Owl Ridge Subdivision Final Drainage Report

Colorado Springs, El Paso County, Colorado

March, 2022

Please Add PCD File
MS-22-005

### FIGURES 3 & 4

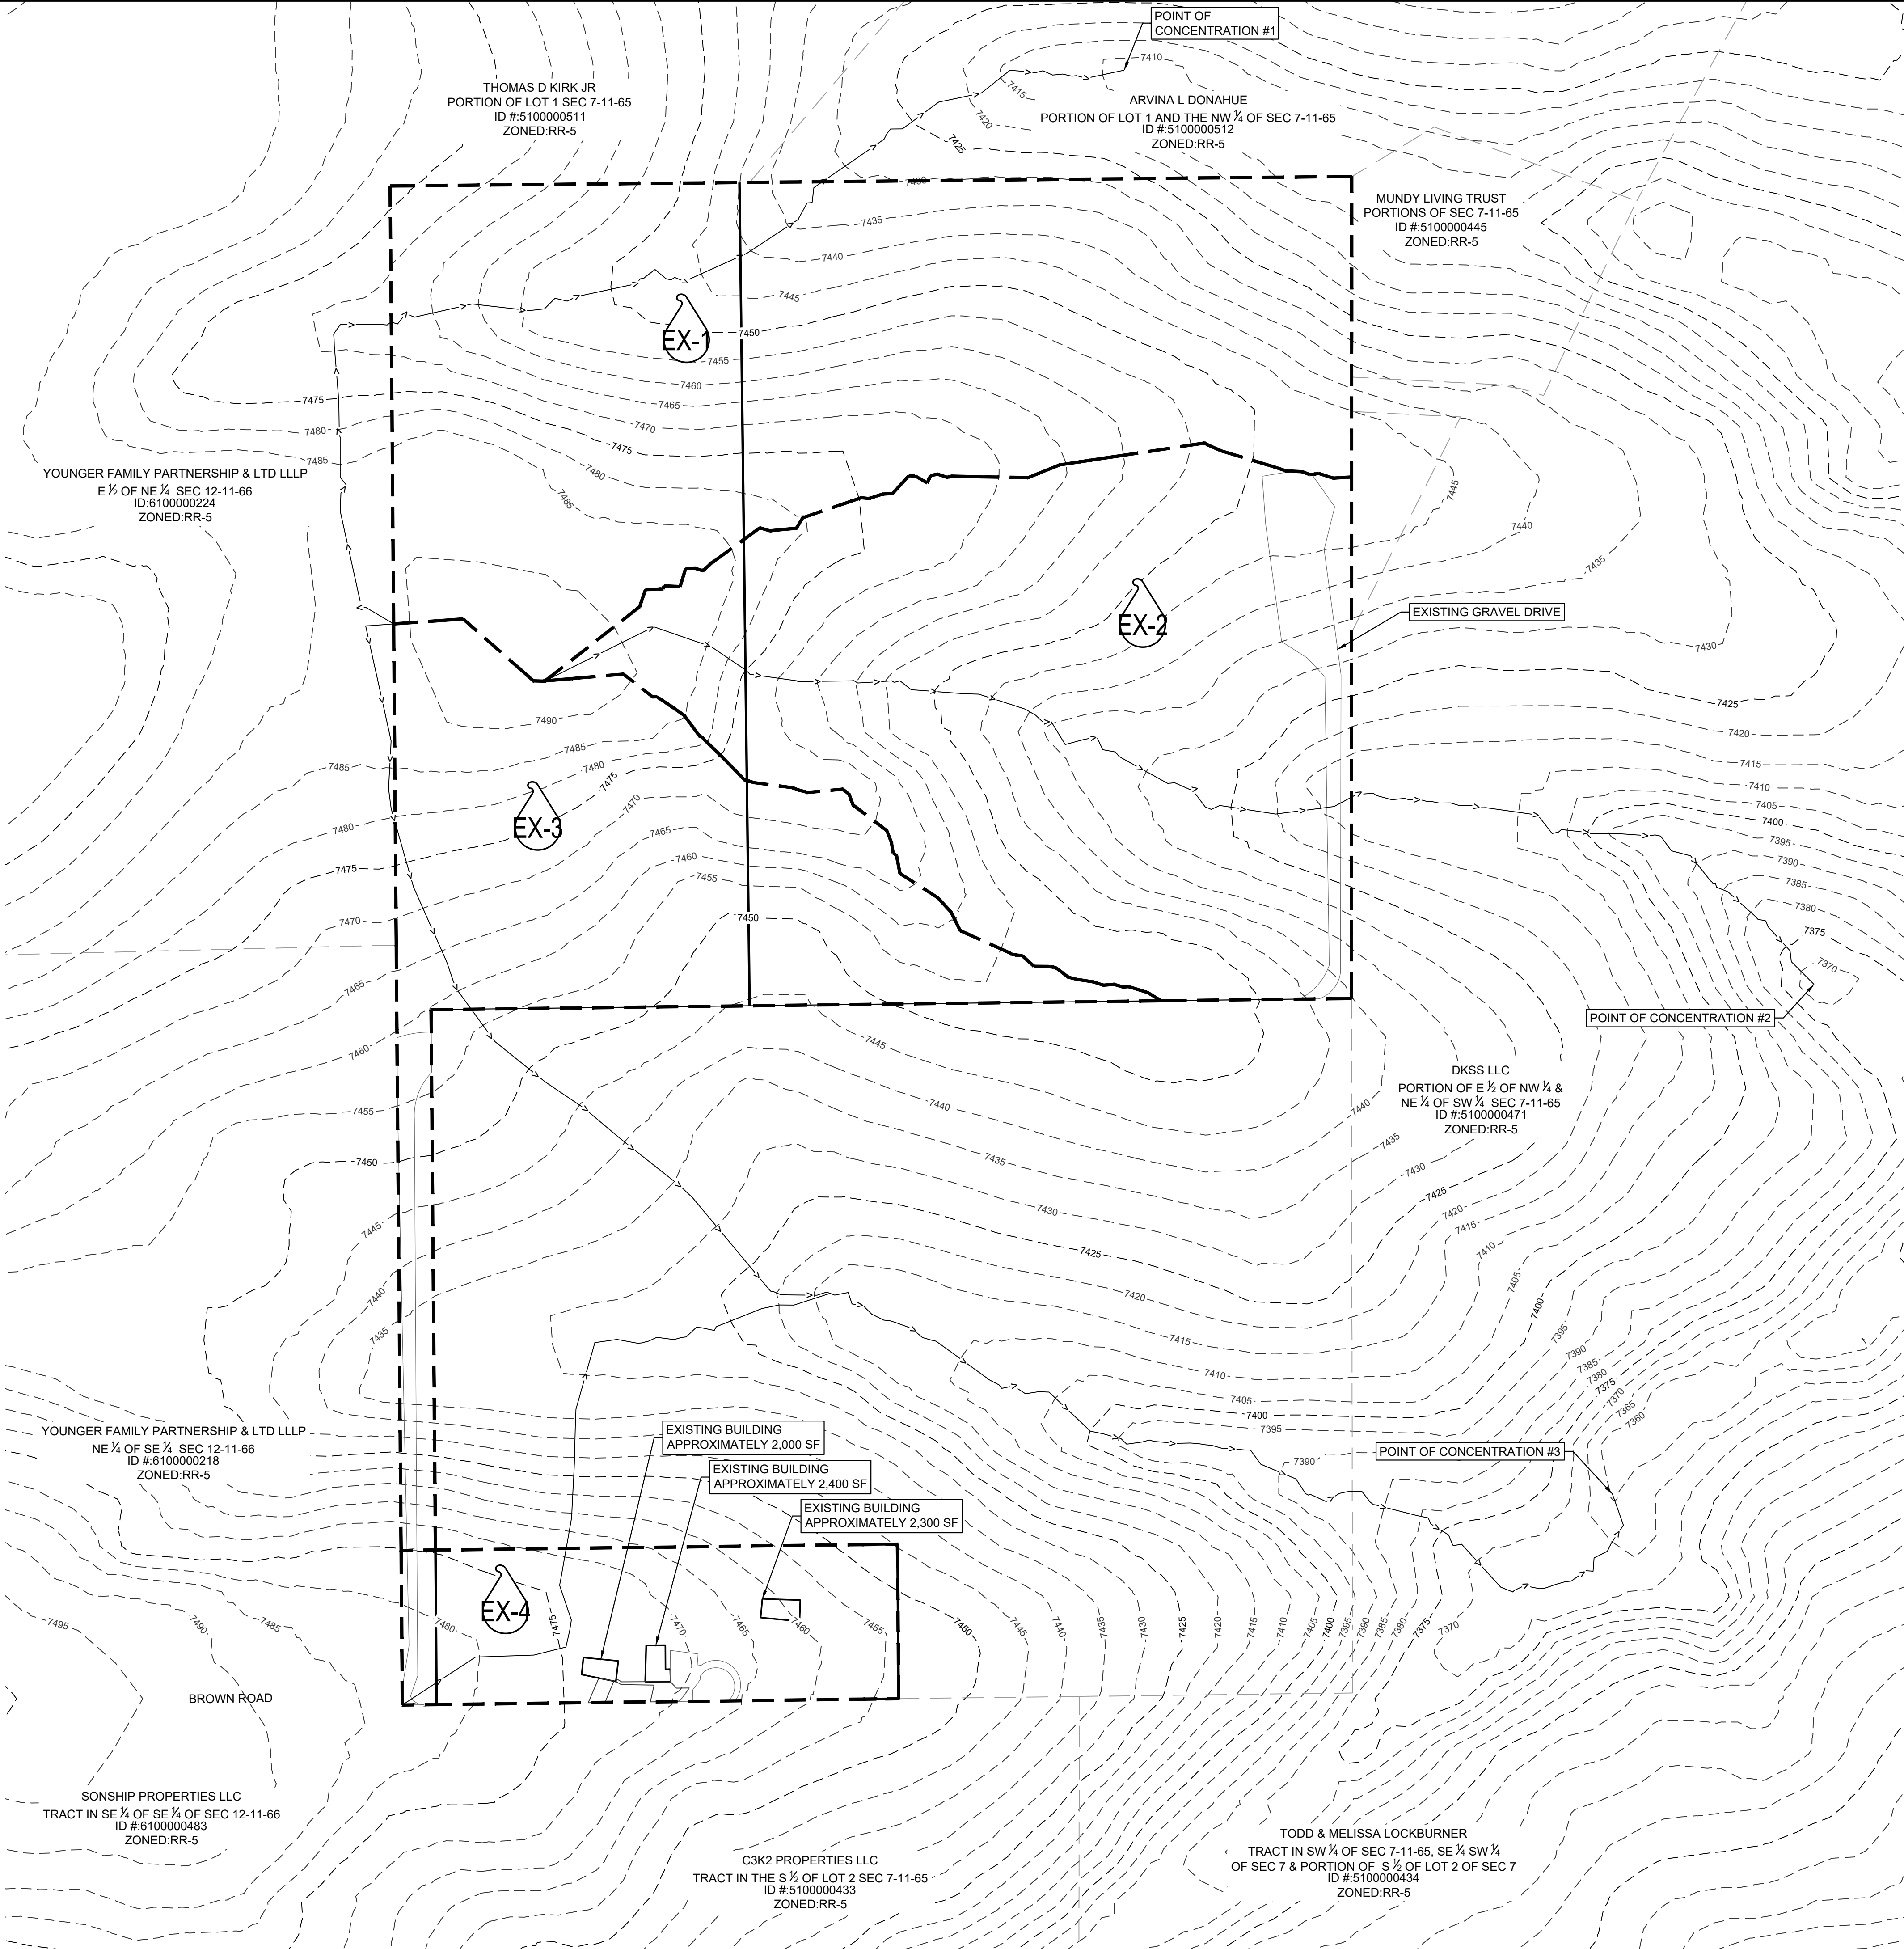
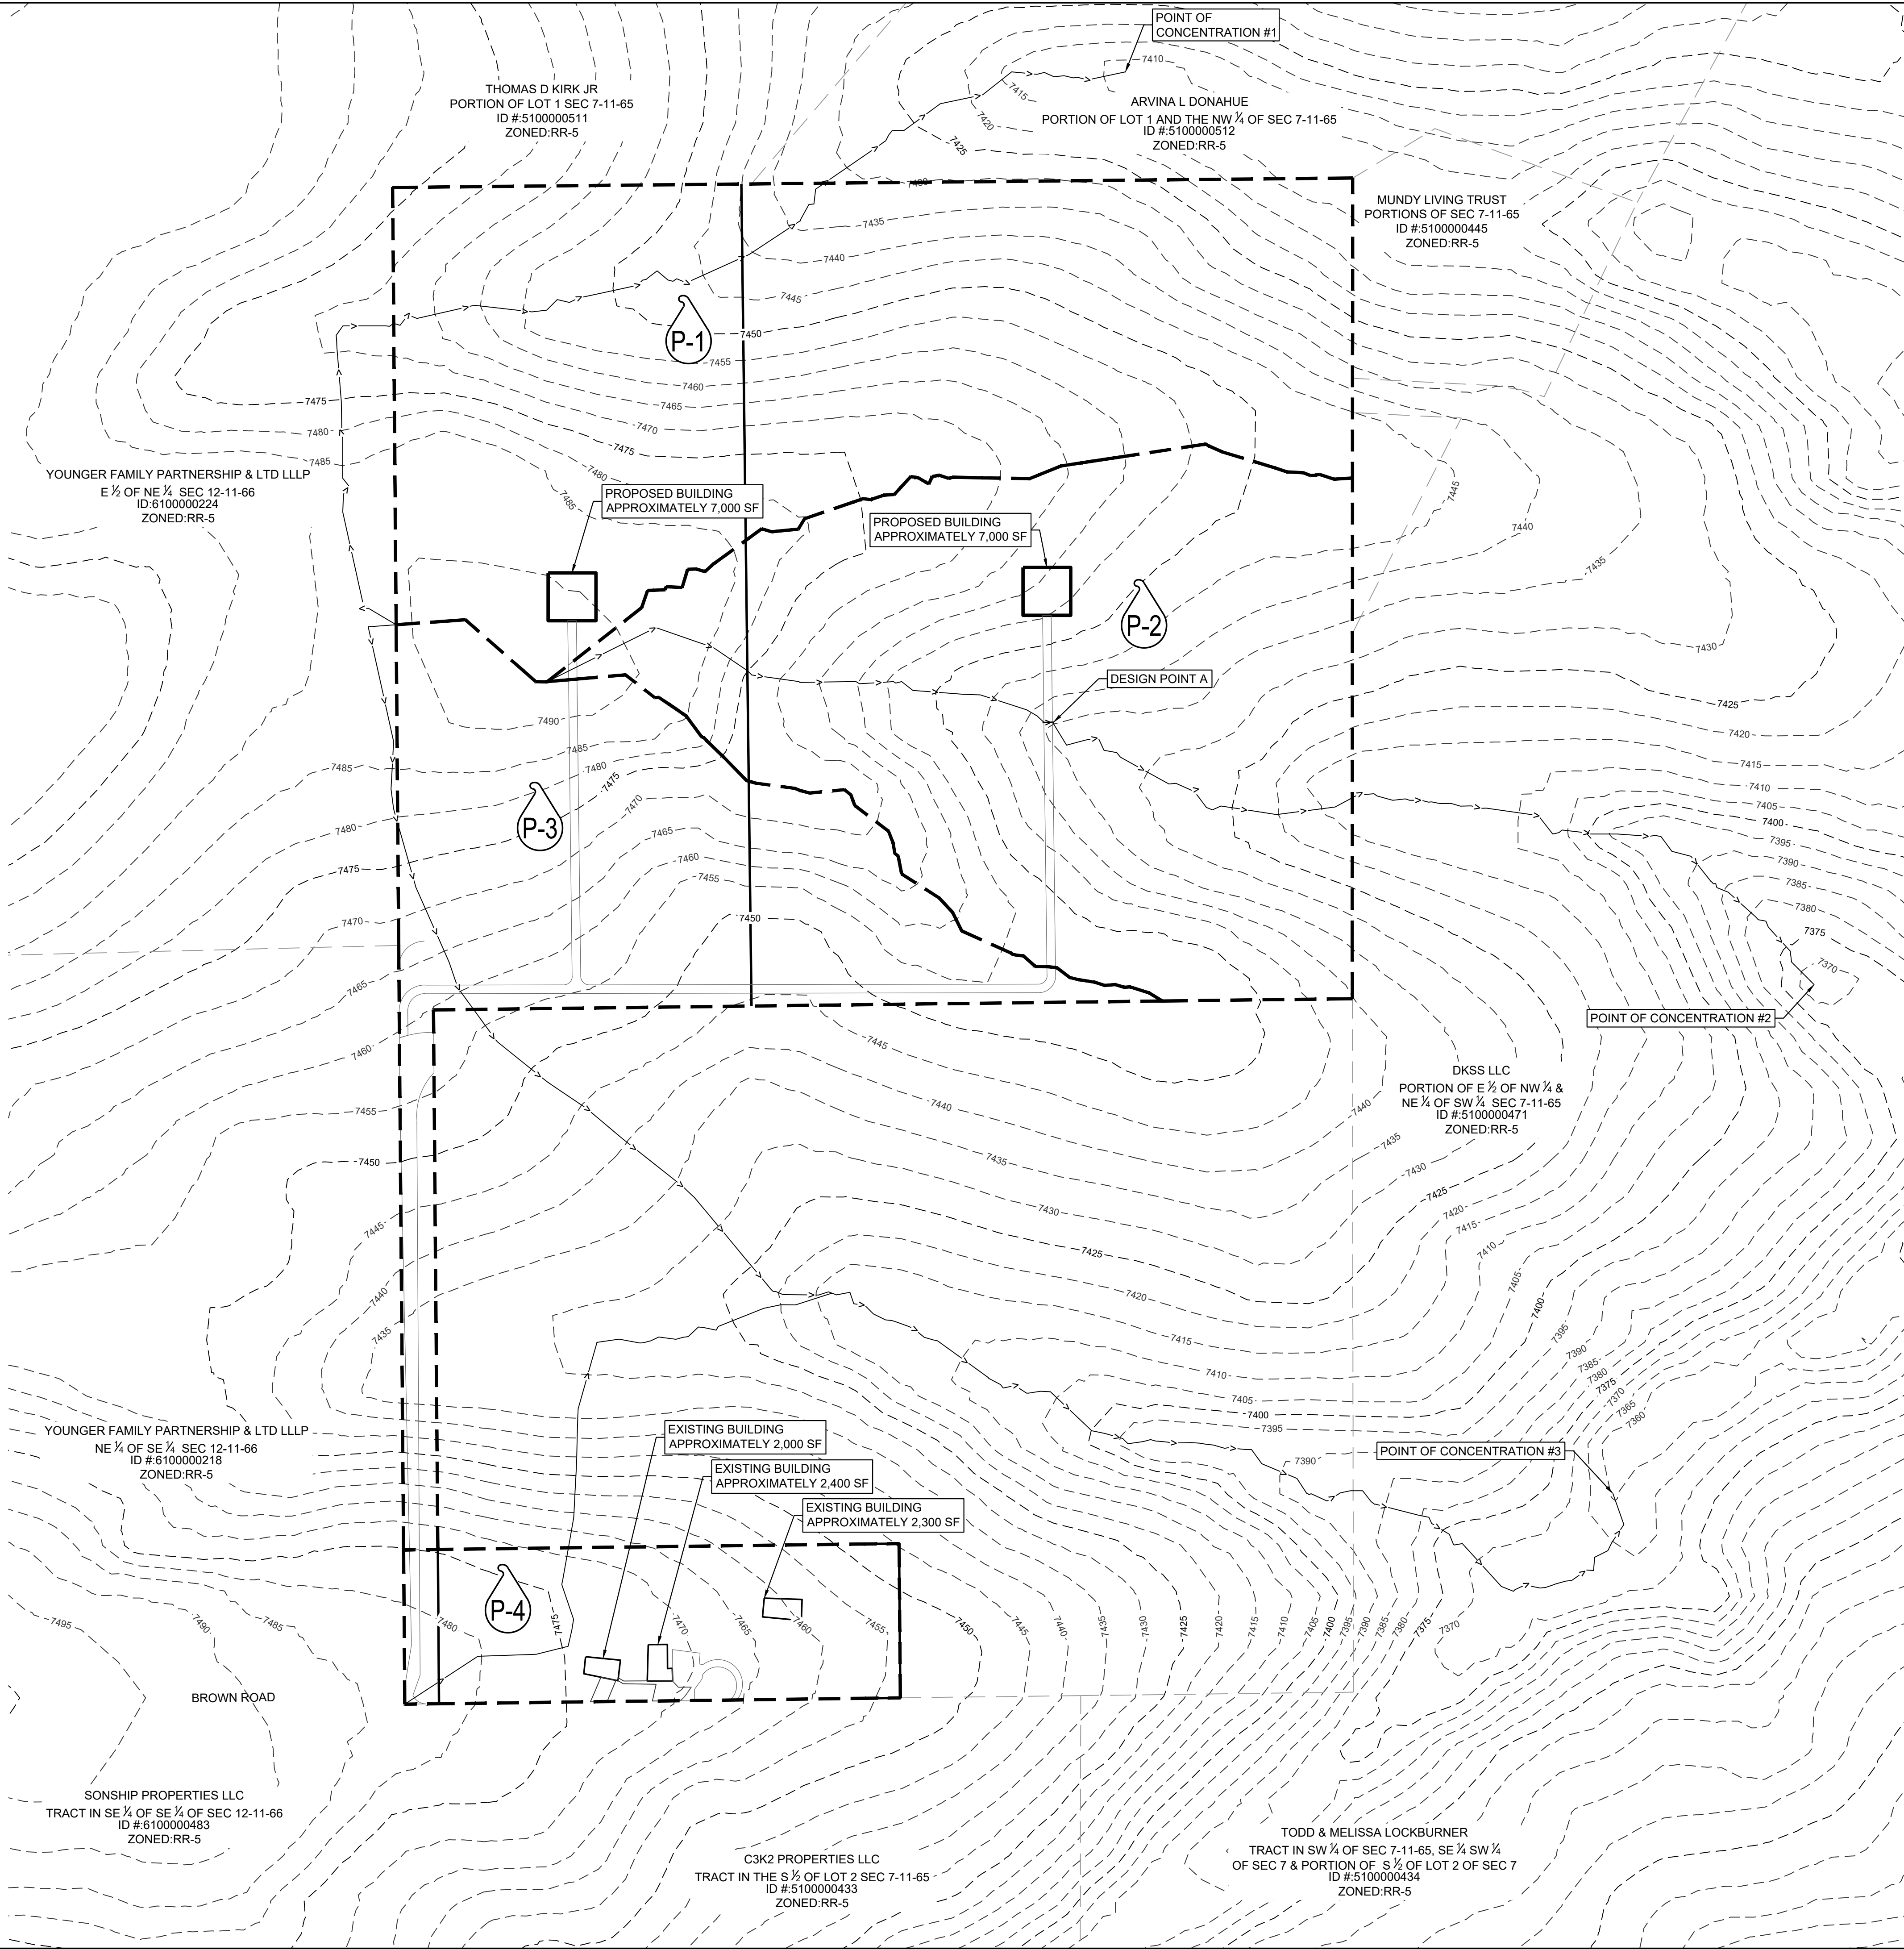
Update the basin description and drainage maps to show/include the offsite drainage basin areas draining into the property.
